ENG-MS21002-R1-Plat.pdf Markup Summary

Subject: Cloud+
Page Index: 1
Date: 3/30/2021 3:39:10 PM
Author: Ryan Howser
Color: ■
Layer:
Space:
Page Label: Sheet 1 - Cover

Subject: BoCC Certification
Page Index: 1
Date: 3/31/2021 1:41:46 PM
Author: Ryan Howser
Color: ■
Layer:
Space:
Page Label: Sheet 1 - Cover

FINAL PLAT
BRADLEY POINT FILING NO. 1
JOB NO. 70-074
DATE PREPARED: 01/29/2021
DATE REVISED: 04/19/2023

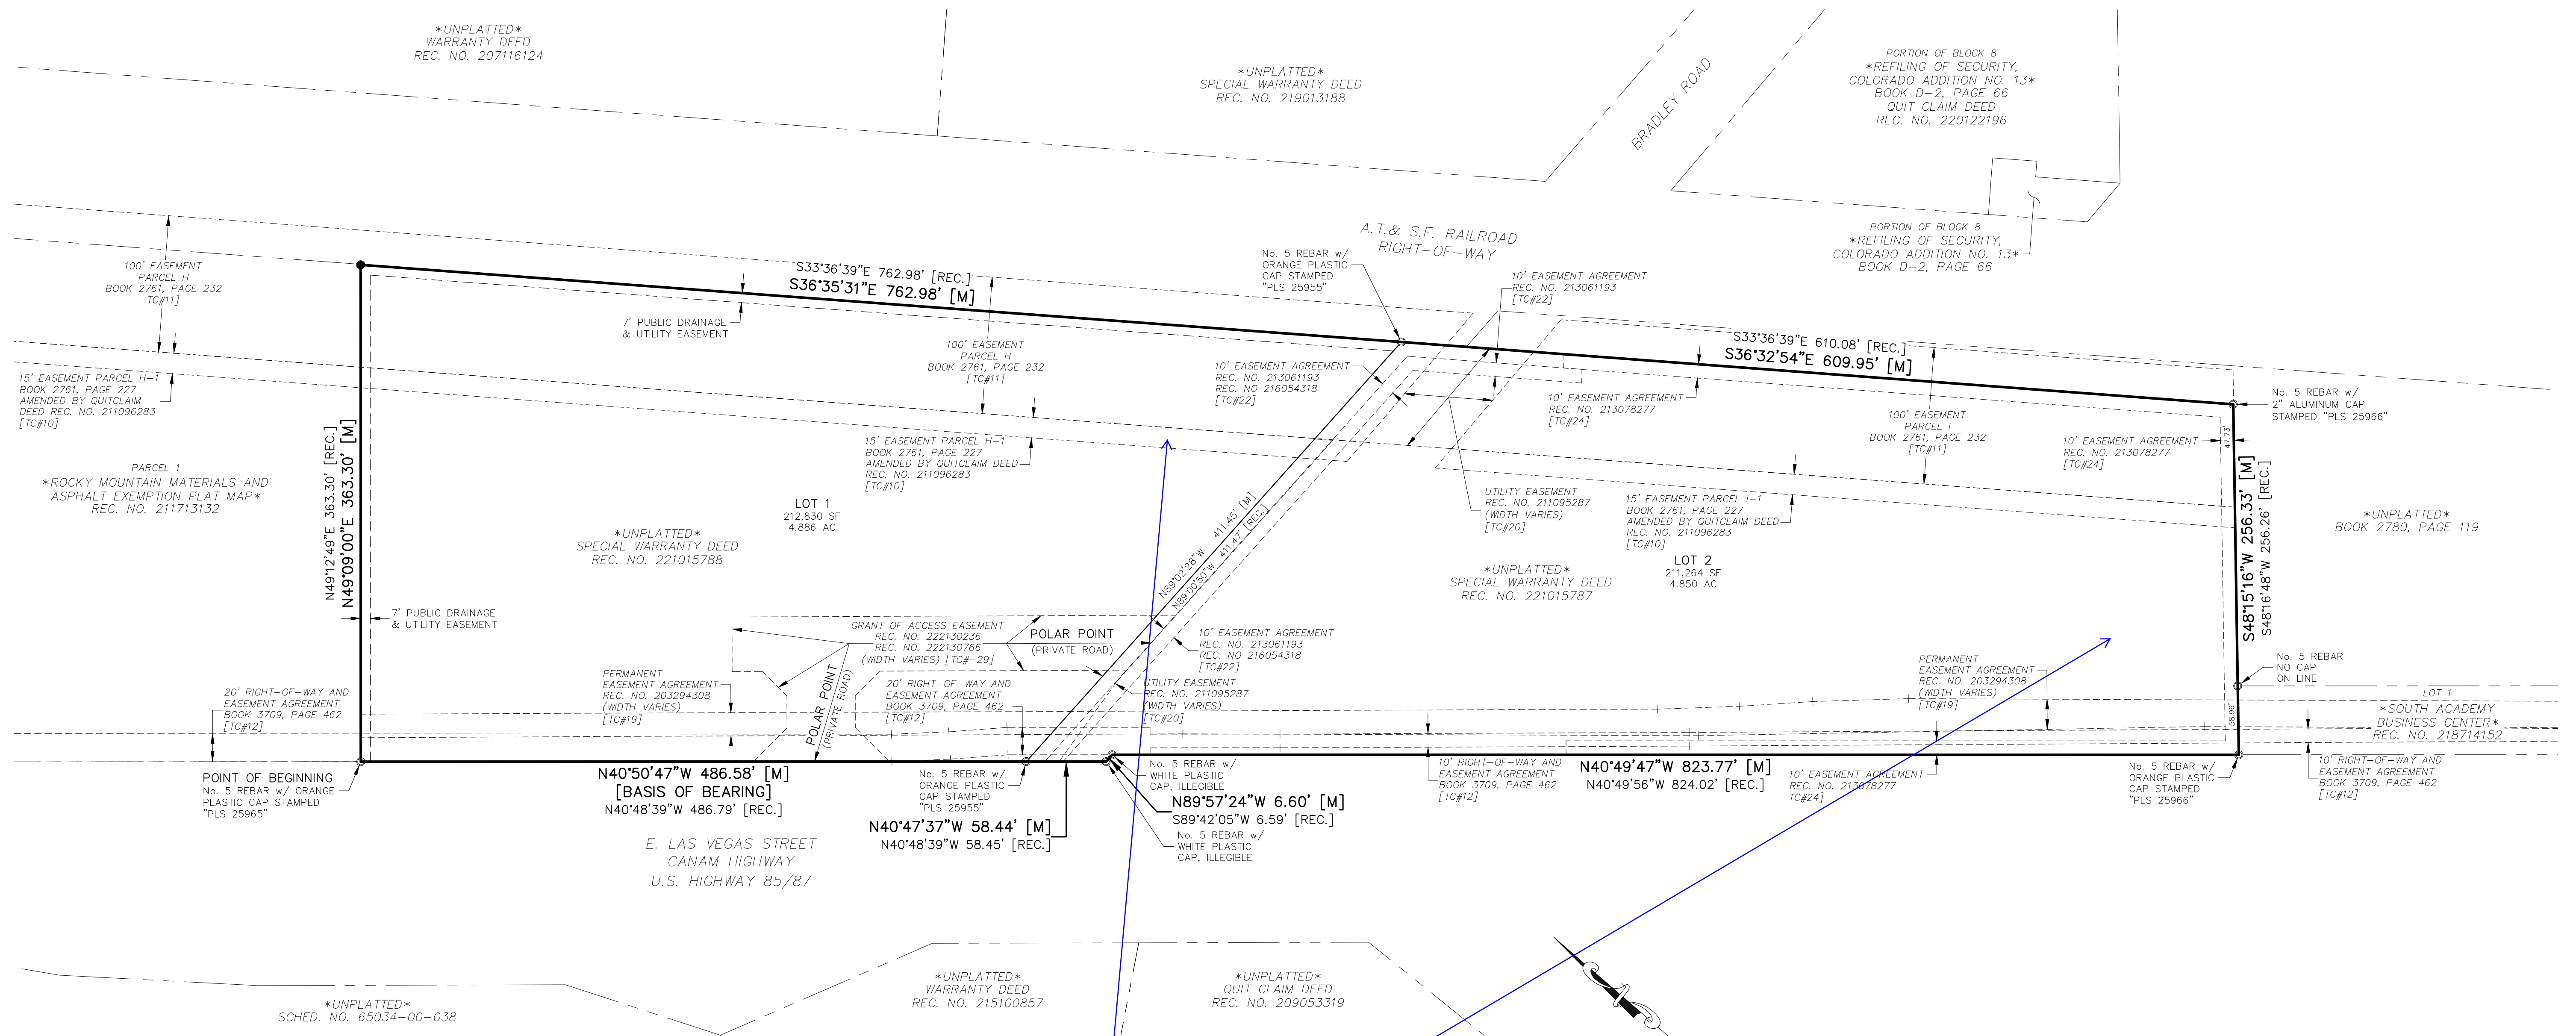
No SIA has been submitted with this plat. If there will be no improvements, please remove this note.

Include a note indicating that this is a dry subdivision and limits the uses to those that do not use water. Any proposal to use water would require a finding of water sufficiency to be made.

Fill in please

This is just the SE 1/4 of Section 3 (revise on both pages)

This does not qualify for administrative final plat. Please revise accordingly.

CDOT

Are there dedications? If not, this note needs to be changed.

Private

Bradley Point (?)

label this line
